Assessment

Recommendation

Refuse

streetscape elevation from Church Hill

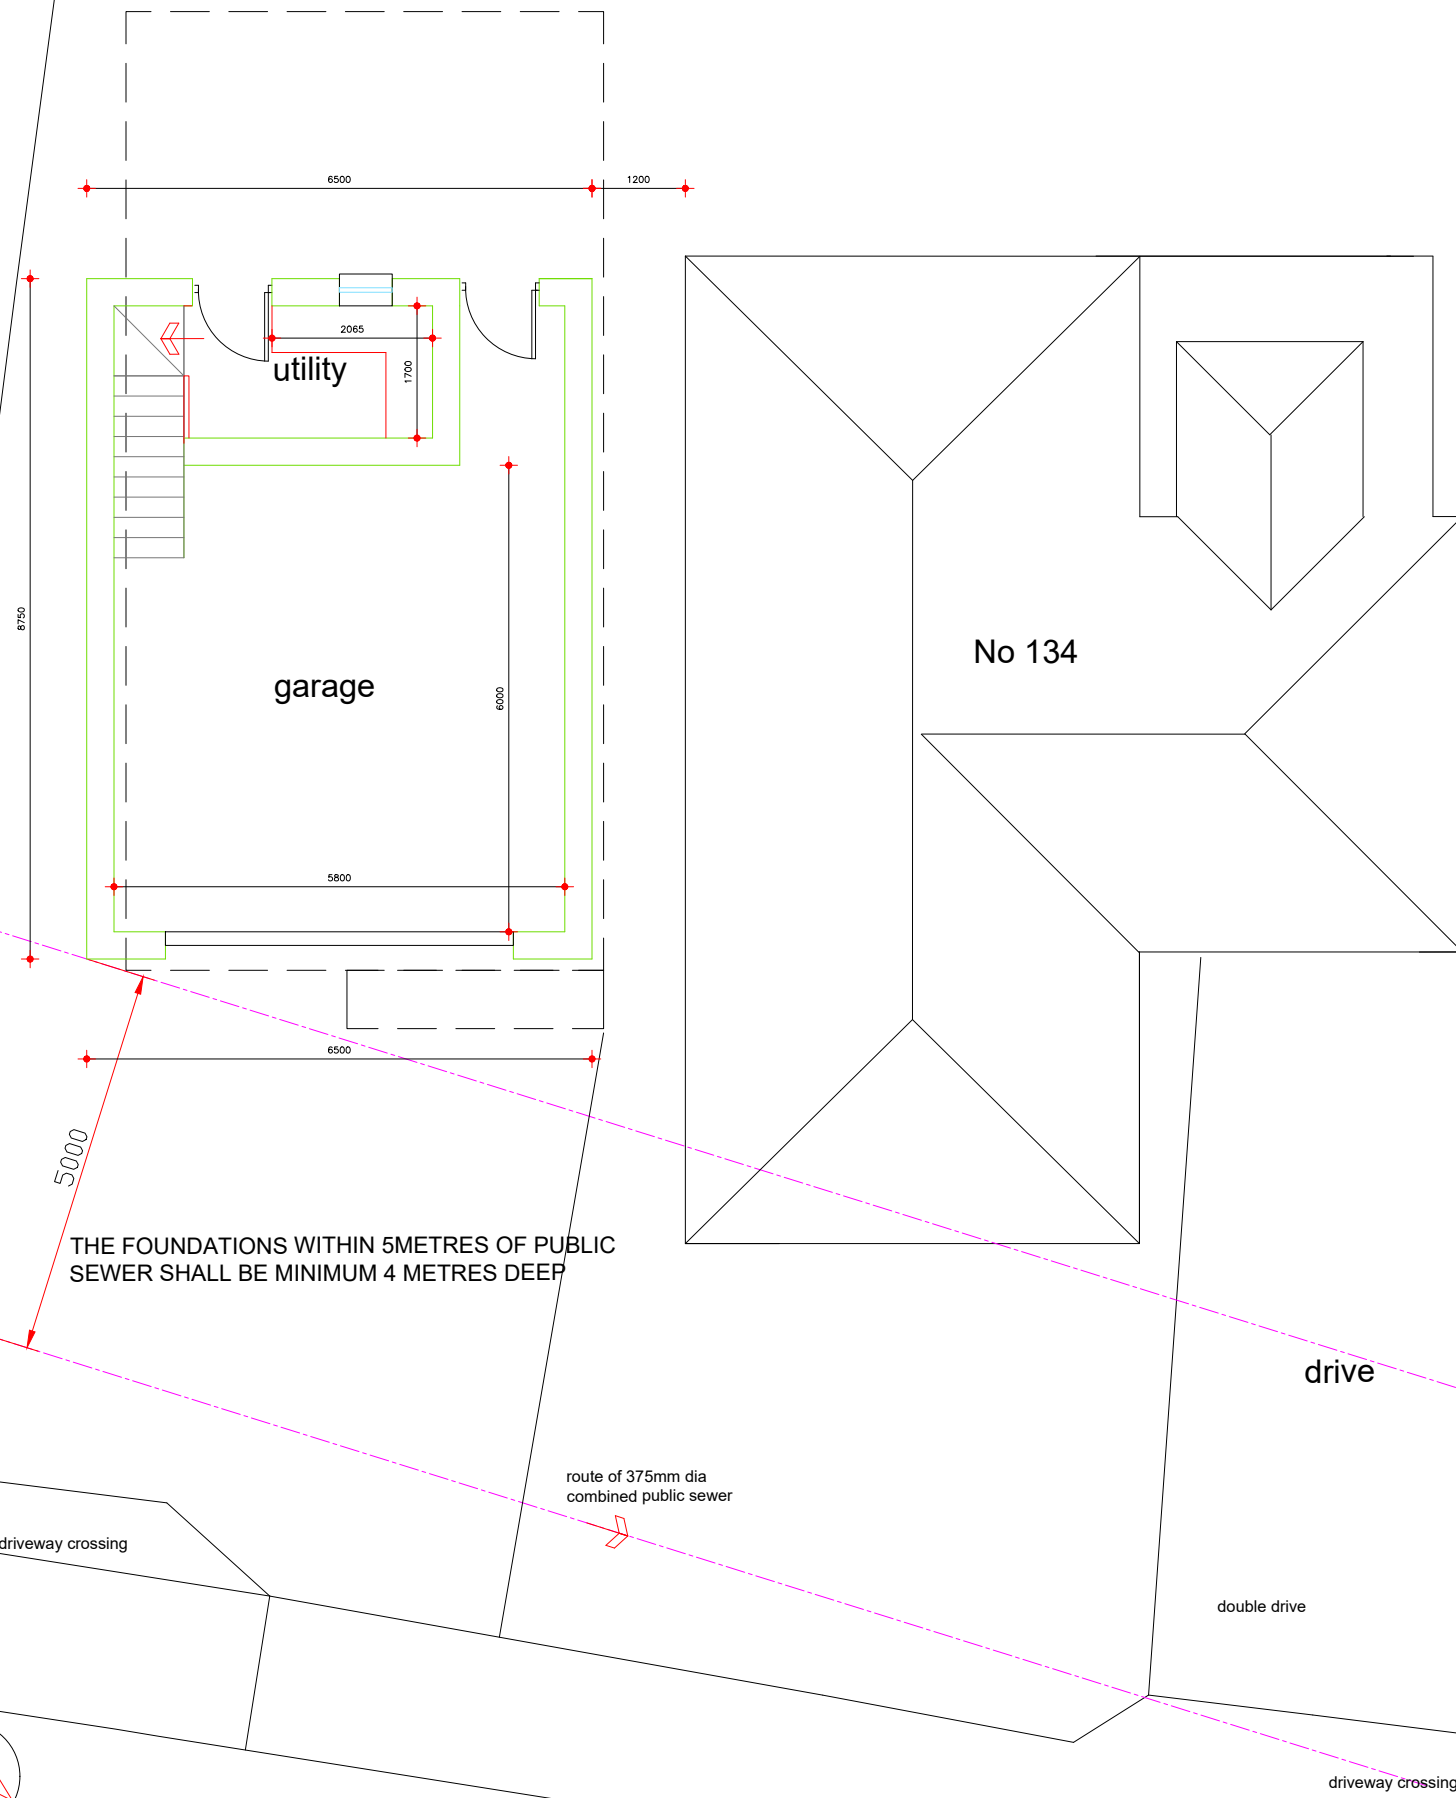
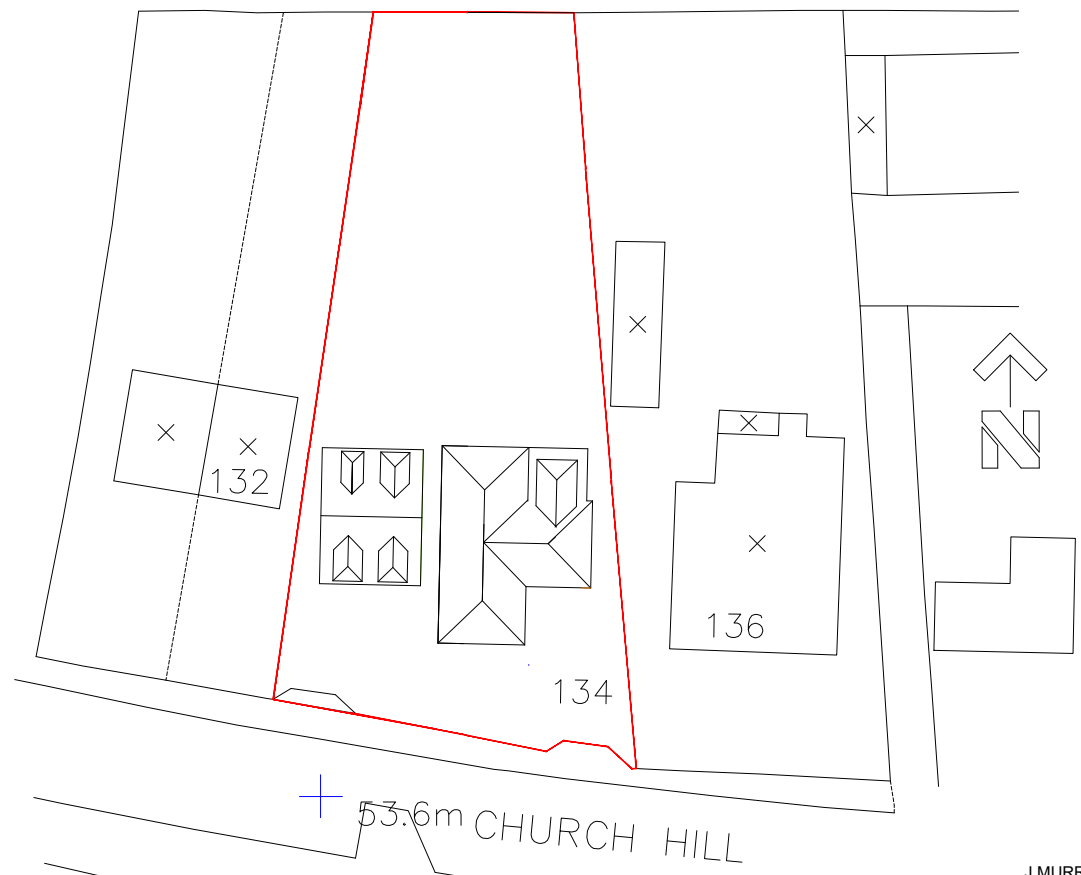
The SPD states that "*outbuildings should relate sympathetically to the main dwelling in style, proportions and external finishes. An annex building may be permitted in a rear garden where it would not occupy a disproportionate amount of the garden and would not have its own separate access or garden area*". The building is not subordinate to the host dwelling nor located in the rear garden. It would appear as a standalone dwelling in the street scene and not that of a dependant residential annexe.

Nonetheless given the prominent location of the building in the street scene and the addition of the front facing dormer windows in the roof plane the annexe would still be detrimental to the visual amenity of Church Hill. The proposal would create an anomaly in the street scene especially as it is set forward of the adjacent semi-detached dwellings, hence creating a focal point and dominant feature within the street scene. The proposal results in an unsympathetic design that does not reflect the development pattern of the area as dormer windows are not present on any front elevations in view of the host dwelling. There is a side dormer window at 136 Church Hill, however this dwelling is single storey, and the dormer window is significantly less prominent. The proposed development is therefore considered to be contrary to Local Plan Policy D1: High Quality Design and Place Making and is considered unacceptable in terms of visual amenity.

front elevation

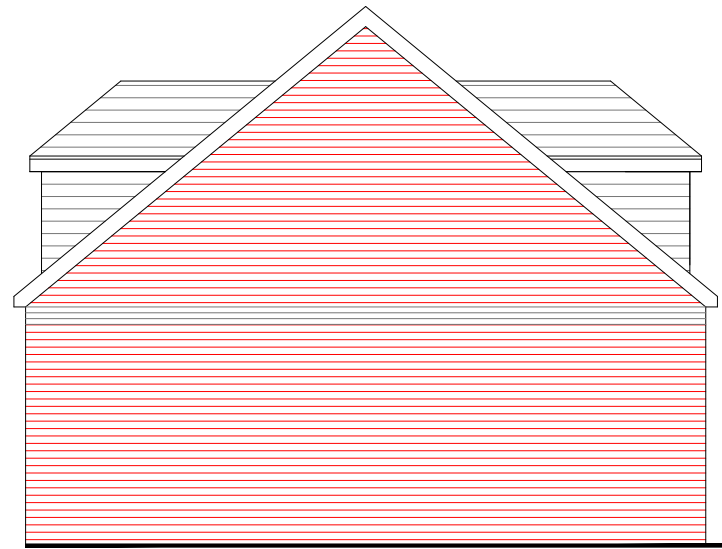
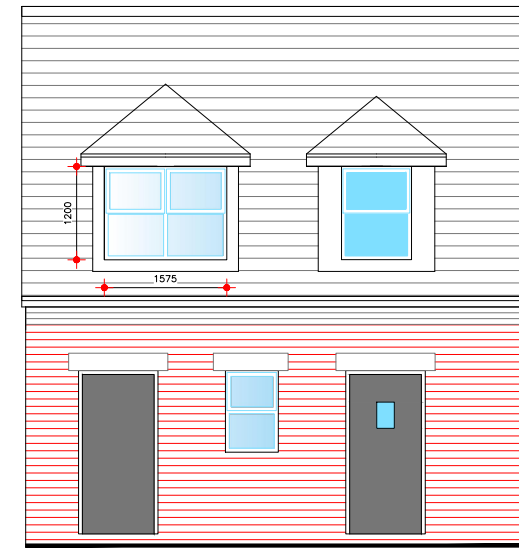
The SPD states that "*detached garages should be single storey structures and the eaves height should not normally exceed 2.5 meters from ground level*" and "*it is not considered appropriate for detached garages to include dormer windows as a way of accommodating rooms in the roof space*". The proposal is a clear contradiction of this and although set in a large curtilage being located to the front of such further highlights its impact upon the street scene. The building would be immediately adjacent to Church Hill and would be highly visible from public vantage points. In addition to the large footprint, the building would also have a total height of 7.15 metres in order to accommodate the rooms within the roof space. This would further add to the visual prominence and scale of the building which therefore does not appear ancillary to the host dwelling and is contrary to the SPD guidance for both annexes and garages.

first floor plan

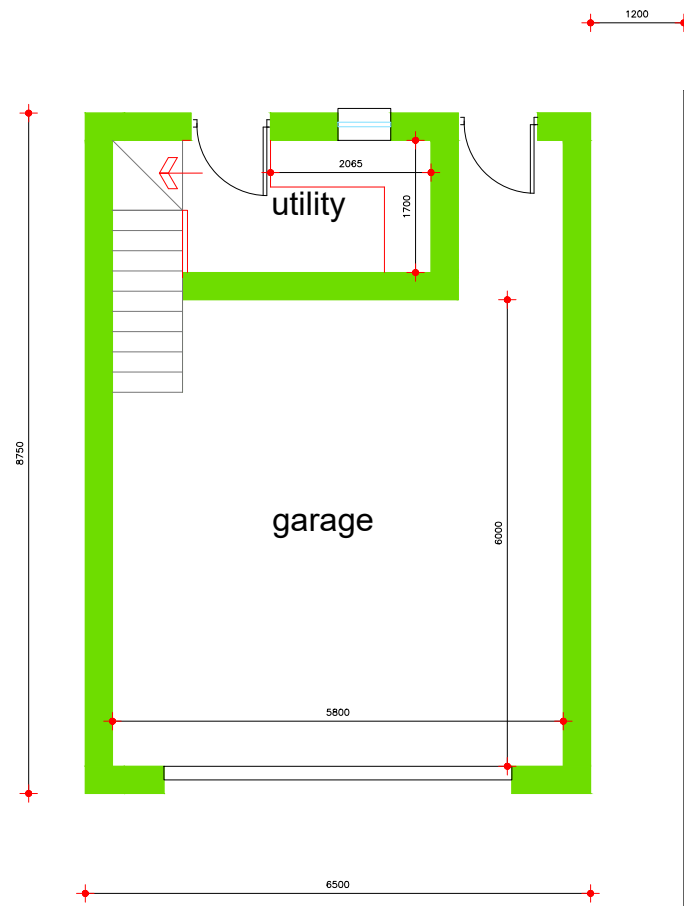
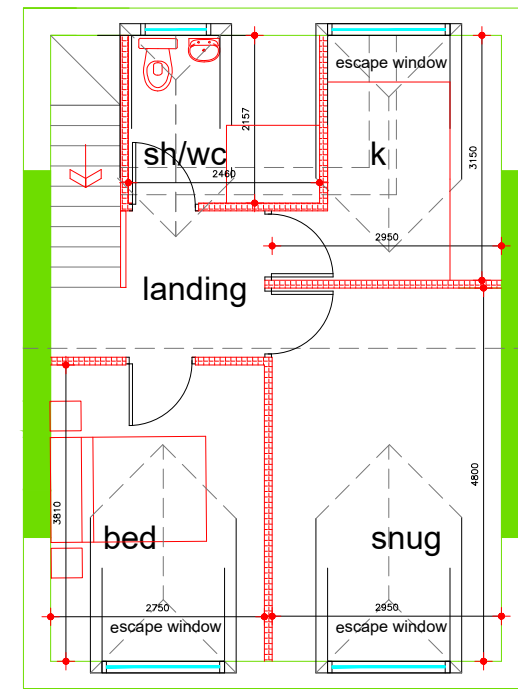
The SPD states that *“an annex should normally have a close physical relationship with the host dwelling, be single storey and in all circumstances it should only have 1 bedroom and no more than 3 rooms in total”*. The proposed annexe is substantial and has an internal floor area of approximately 46sqm at first floor level alone. The internal layout shows a bedroom, bathroom, kitchen and snug at first floor level with a garage and utility room at ground floor level. The total usable floor area of the proposed building is 92sqm although it's acknowledged most of the ground floor is the garage.

The South Yorkshire Residential Design Guide states (Internal Space Standards page 130) that a one bed one person property should be a minimum of 46sqm which is akin to the first floor of the building alone. Also, a four bed five person property should be a minimum of 93sqm. The proposed building is therefore significant in size and is the equivalent of an independent dwelling based on the proposed internal floor areas which far exceeds that of a dependant annexe.

The SPD guidance limit annexes to three rooms, irrespective of size. The provision of a bedroom, bathroom, kitchen and snug, would mean that there is no reliance upon the main dwelling for any typical residential facilities. Due to the range of facilities proposed for the unit, it is clear that the proposed annexe could be used as an independent residential unit and separate to 134 Church Hill.
